Ribble Valley Borough Council
Housing & Development Control

Application no: **3/2022/1158**

Address: **Land South of Accrington Road Whalley**

Proposal: **Erection of 17 dwellings and 57 apartments with associated access, roads, car parking, landscaping and infrastructure, including a public car park to serve Whalley town centre**

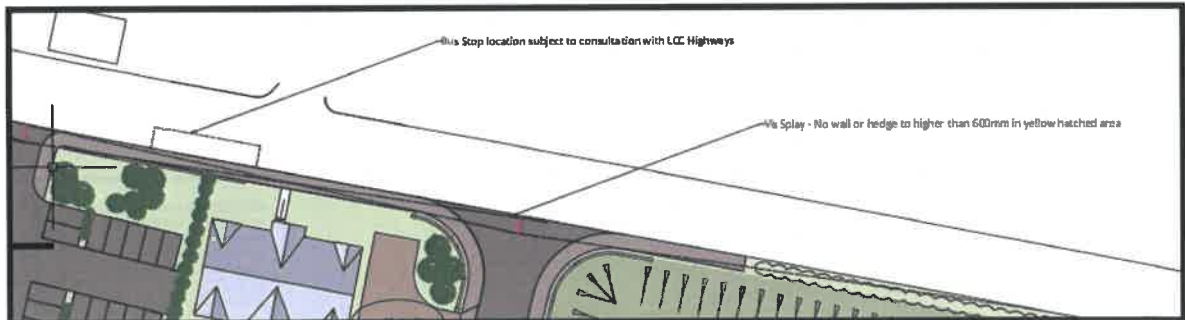
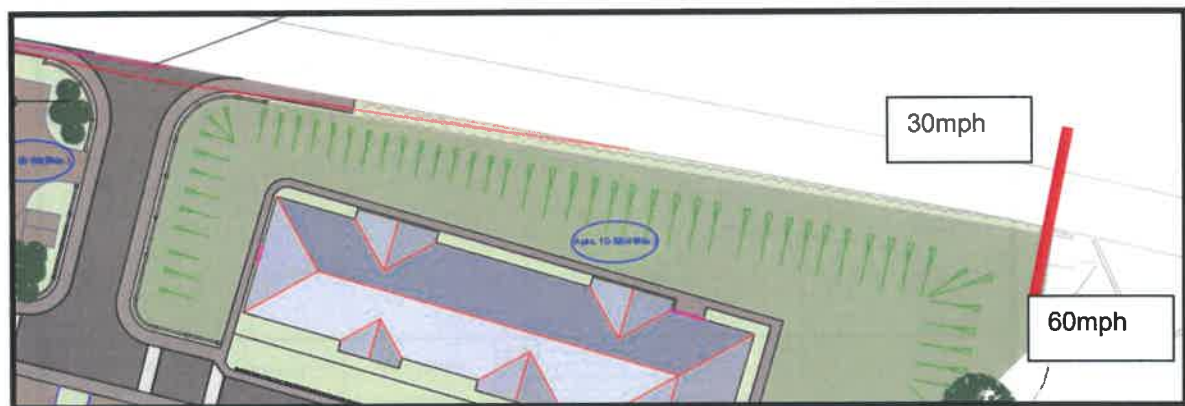
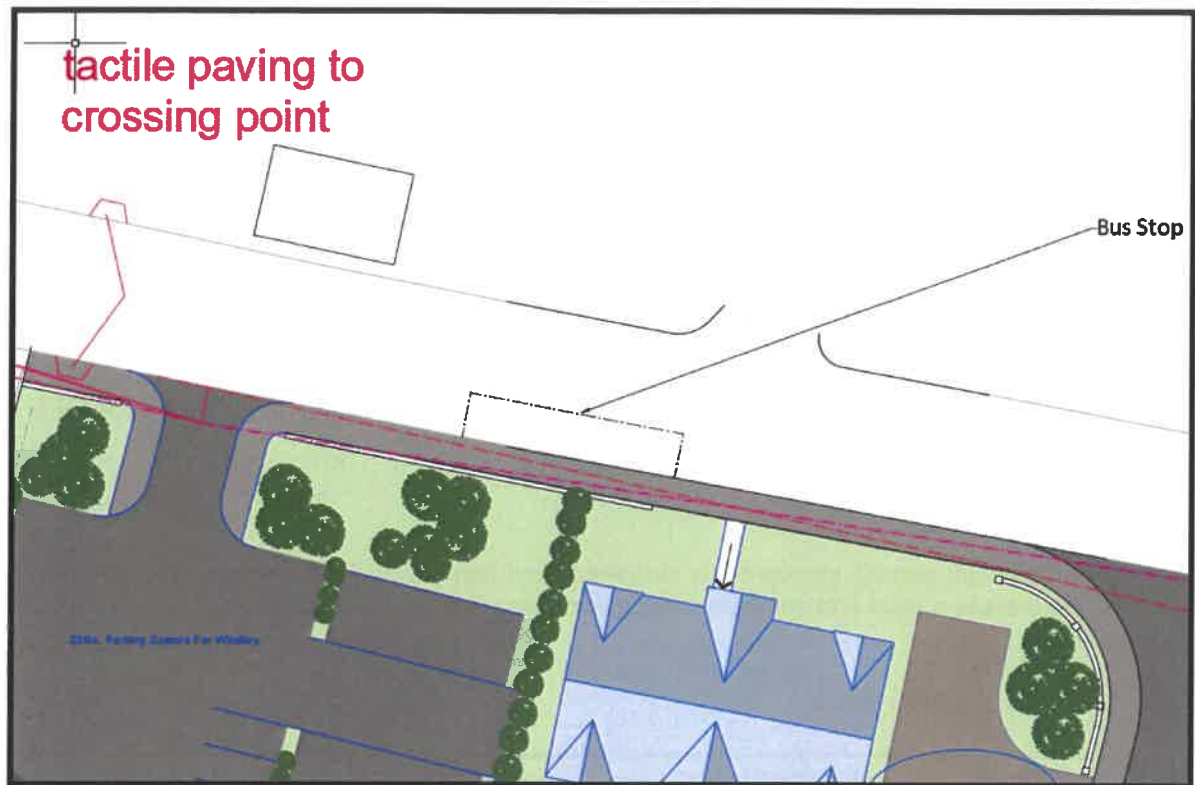
For the sites access to comply with the LHAs guidance, the LHA require visibility splays of 2.4m x 98m are provided in both directions, with the 85th percentile speeds exceeding 37mph.

However, due to the LHA accepting visibility splays of 2.4m x 70m in both directions for application reference 3/2012/0179 which was for a similar scale of development, and the access being able to achieve this as shown on Oakmere Homes drawing number 015/R-OAK/01 Rev H titled "Reduced Development Proposal," the LHA will accept these splays.
